20160433.2/1013/TT/R2

13 October 2017

Lindfield Learning Village – Response to Planning NSW and EPA Queries

Lindfield Learning Village - North (opposite Tubbs View): Monday 12 June, 2017

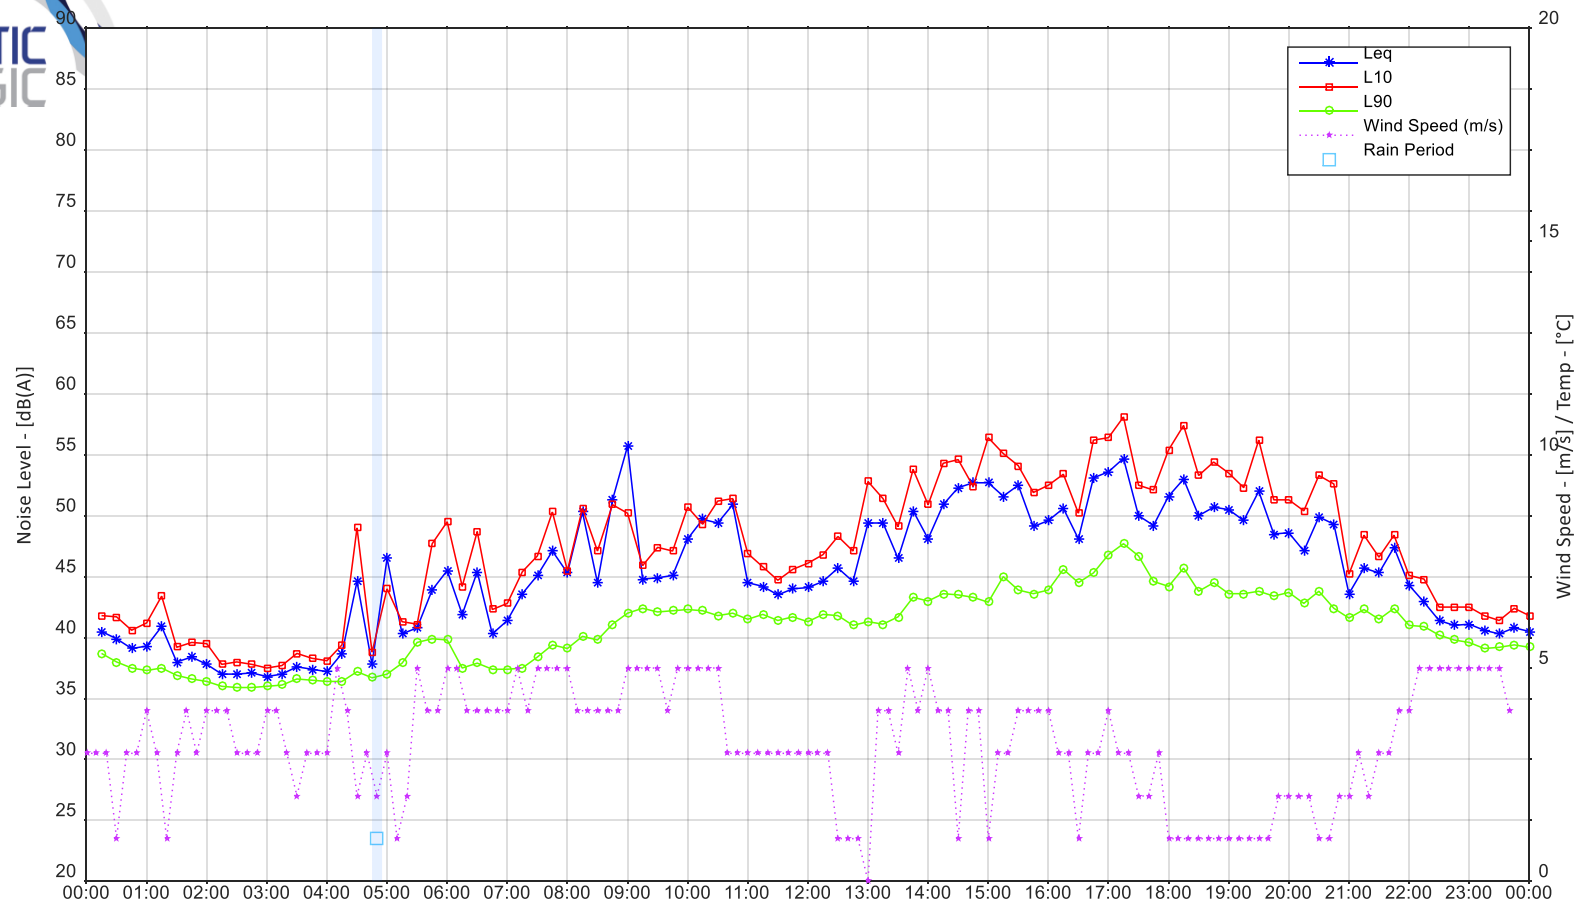
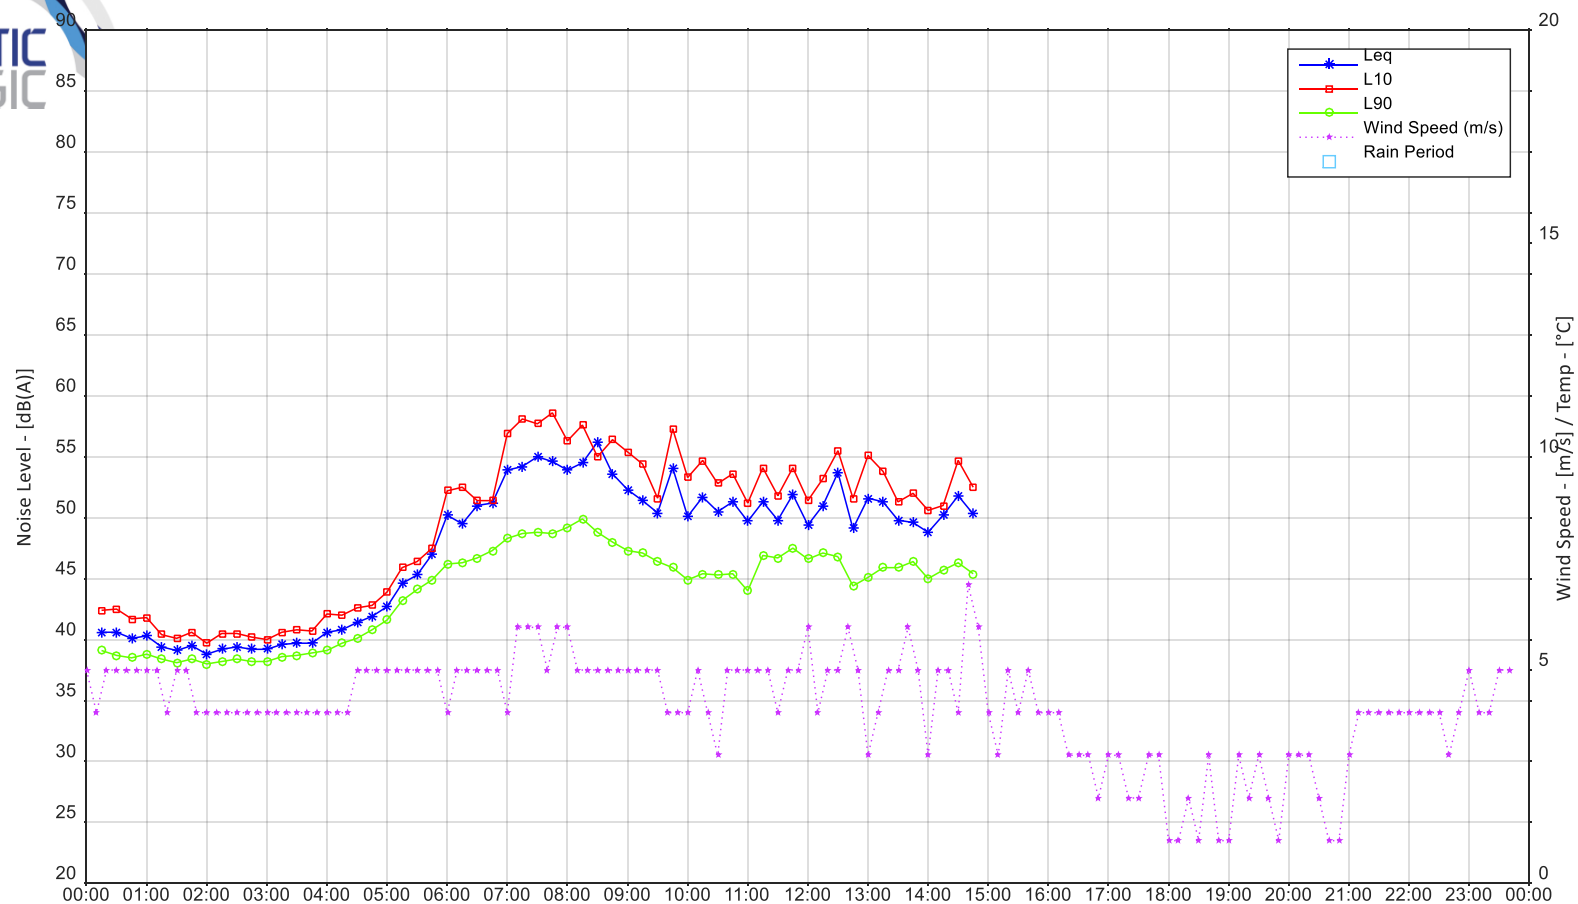
Planning NSW had queried the fact that a noise logger placed at the south of the site was also used to provide representative background noise levels for residences to the north of the site (Tubbs View).

We confirm that additional long term noise logging was conducted at the site near the Tubbs View residences in June 2017.

Logger location is shown in Figure 1 of our amended Noise Impact Assessment (Revision 5, dated 30/10/2017). The logger location was as close as practicable to the Tubbs View residences and is appropriate data for use when setting noise emission goals to these residences.

- Supplementary background noise logging was conducted at the north of the site (near Tubbs View, between 6 and 13 June) which is not affected by filming noise.
